**Re: Warehouse / Distribution and Industrial Facility, Horsely Drive Business Park (SSD 7564)
Response to Submissions**

We refer to item 2 Urban Design & Visual Impacts issued within Attachment 1 – Department of Planning and Environment's Issues of the NSW Government Planning & Environment letter dated 15th July 2016.

LANDSCAPE PLAN
SCALE = 1:200

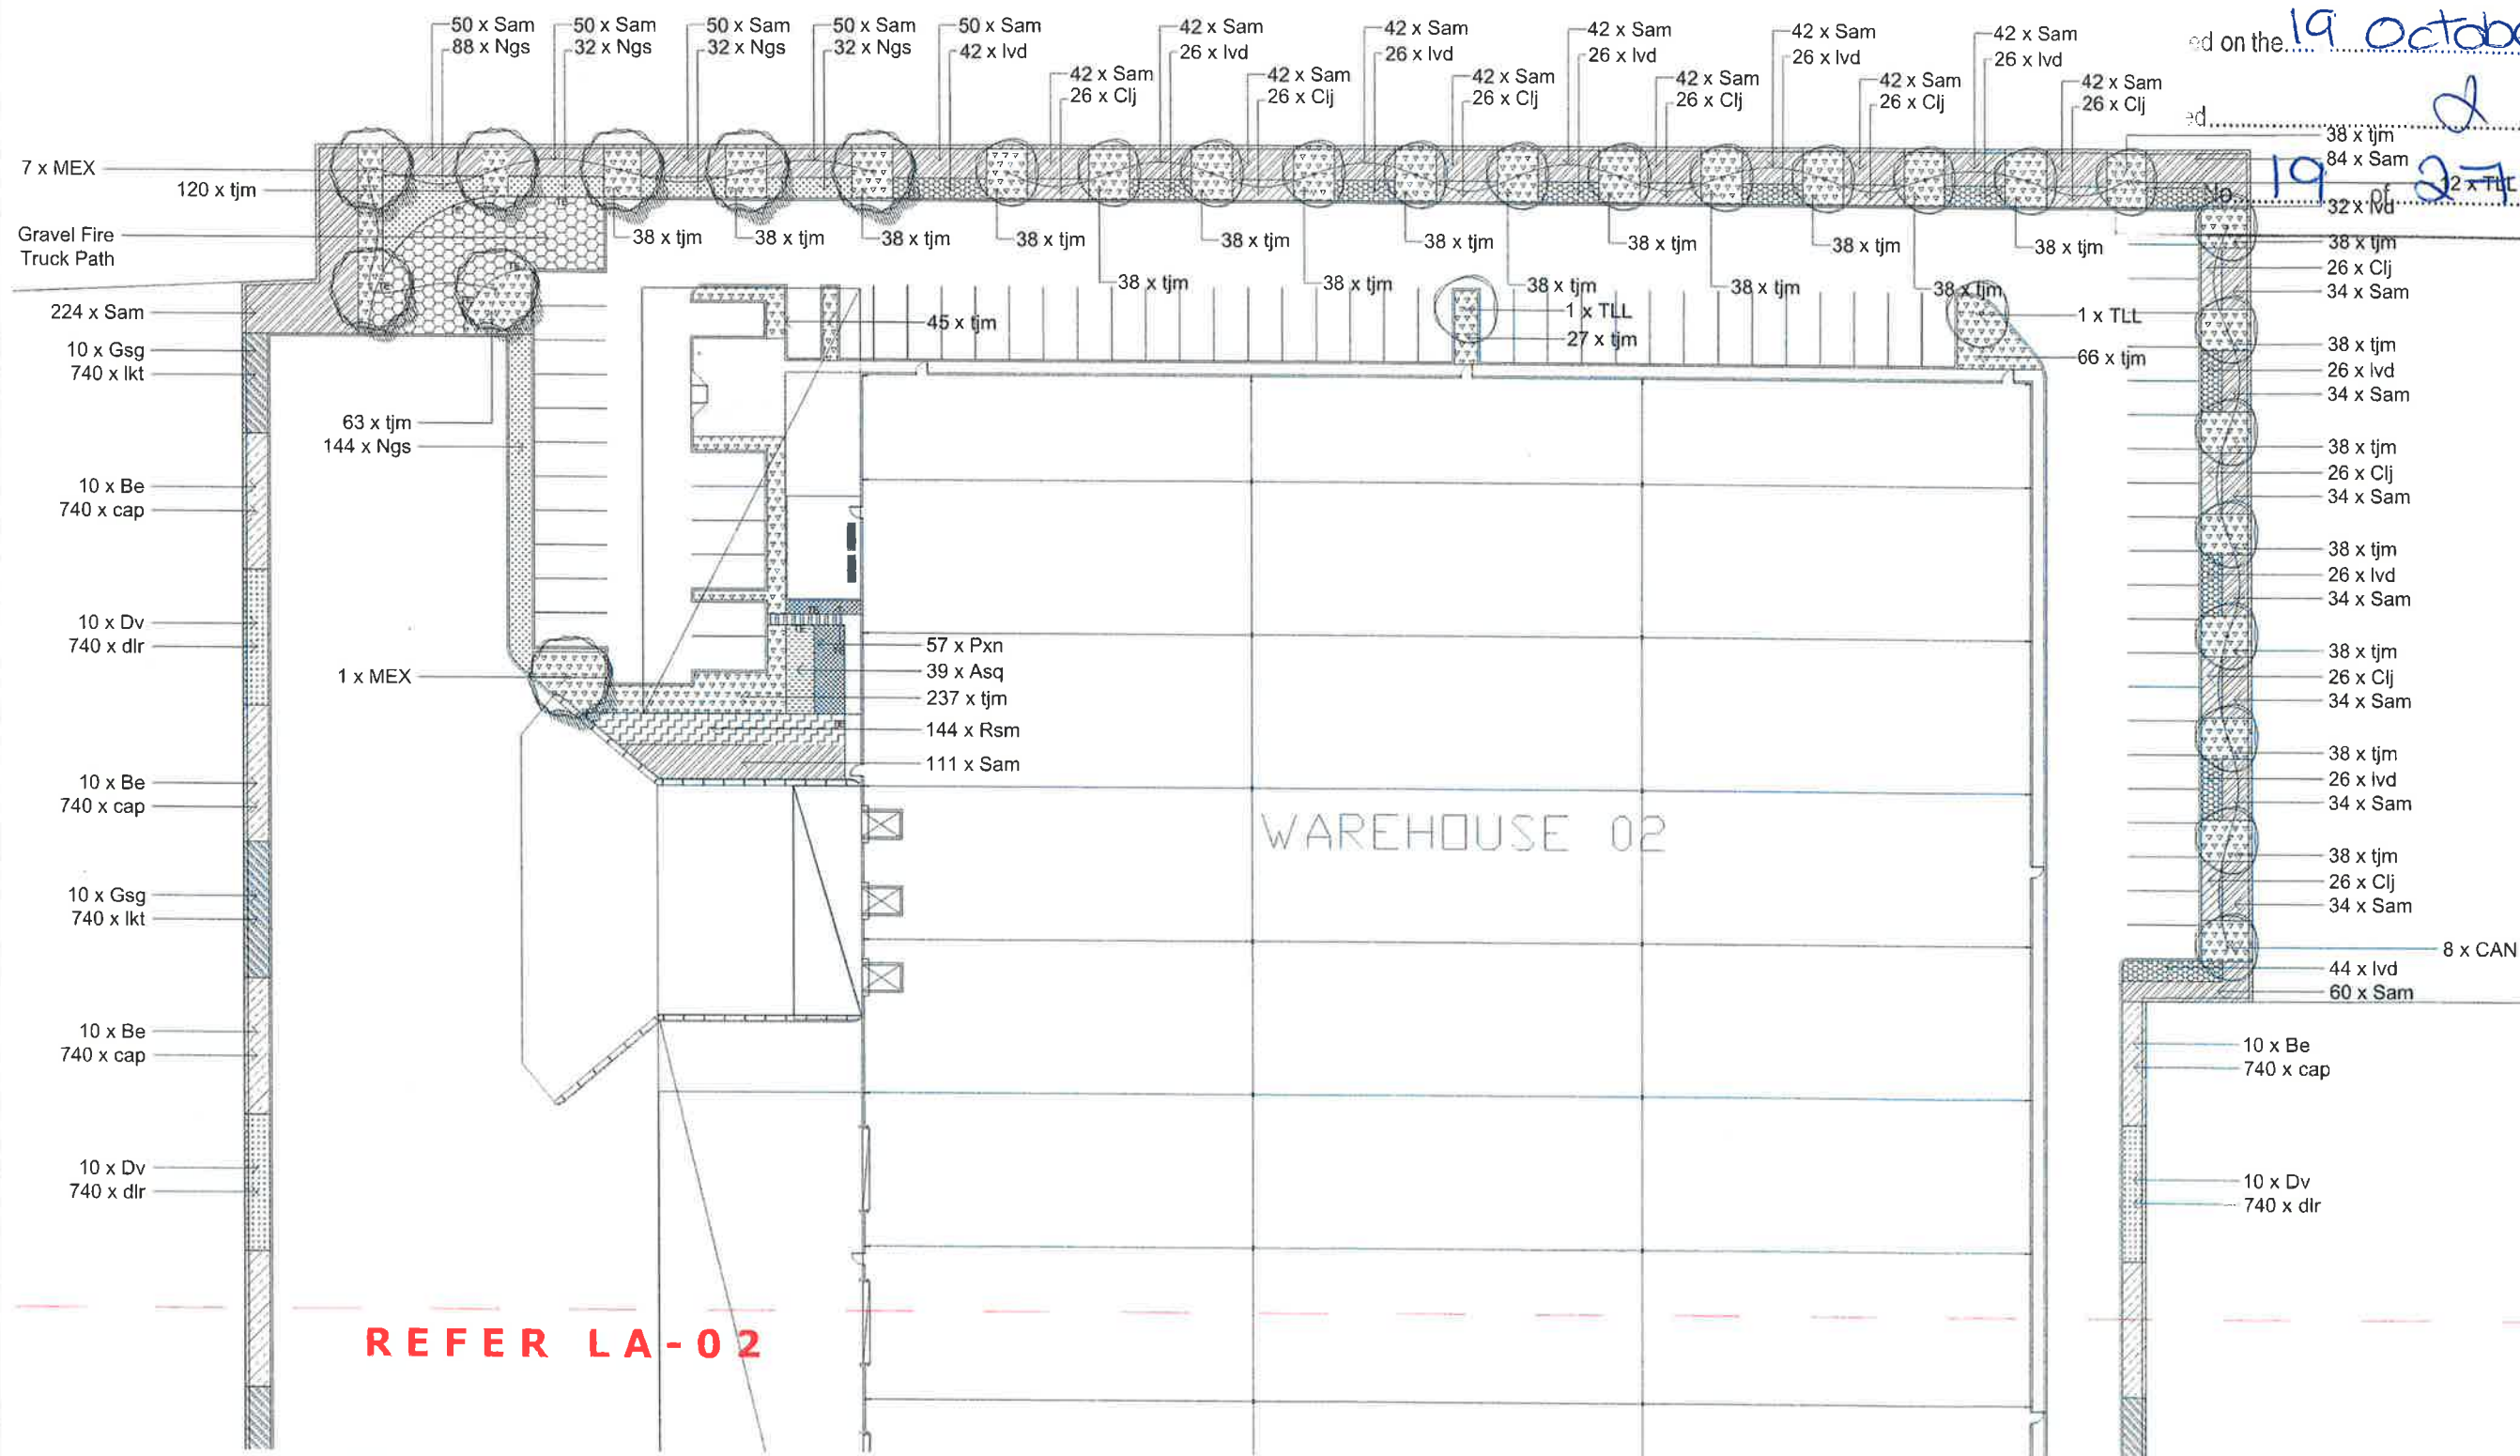
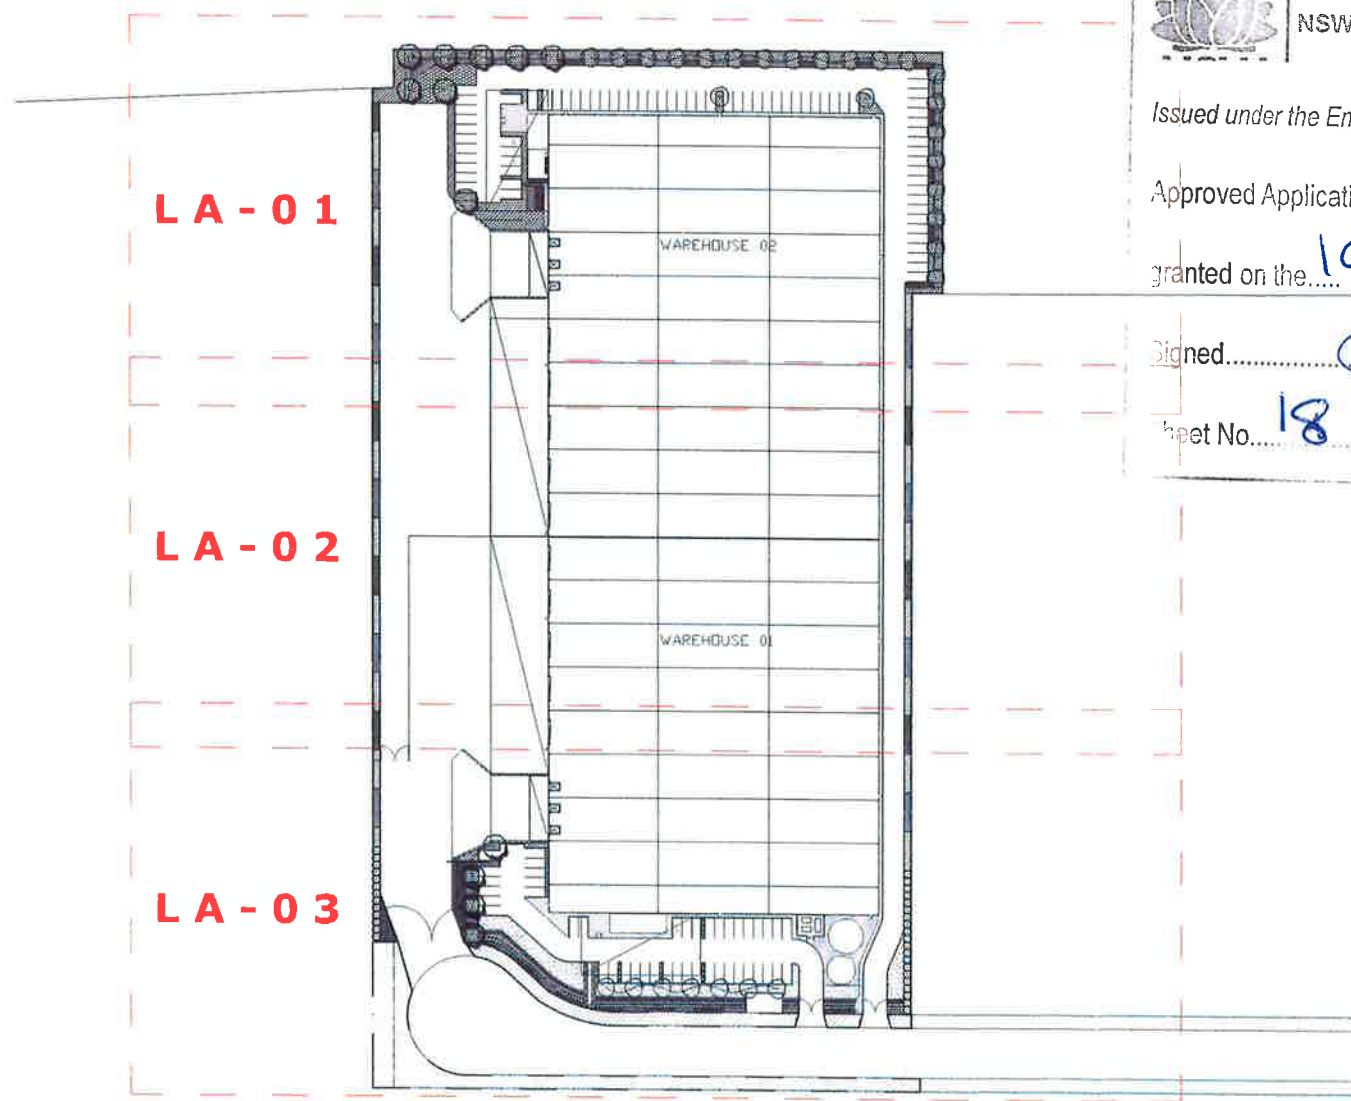
2. Urban Design and Visual Impacts – *Provide landscaping incorporating endemic species, or provide justification for the use of the exotic species identified in the Landscape and Vegetation Management Plan.*

We advise that the current design has made provision for incorporating endemic species. Approximately 90% of the species nominated within the landscape documentation are native. Native endemic species are predominantly located along the boundaries of the site to provide a visual screen from residences & public vantage points. Exotic species have been specified as accent plantings around the office areas and along the active frontages. The proposed exotic species have been utilised sparingly and often in conjunction with native species to assist in providing a higher quality landscape finish along the more prominent portions of the site.
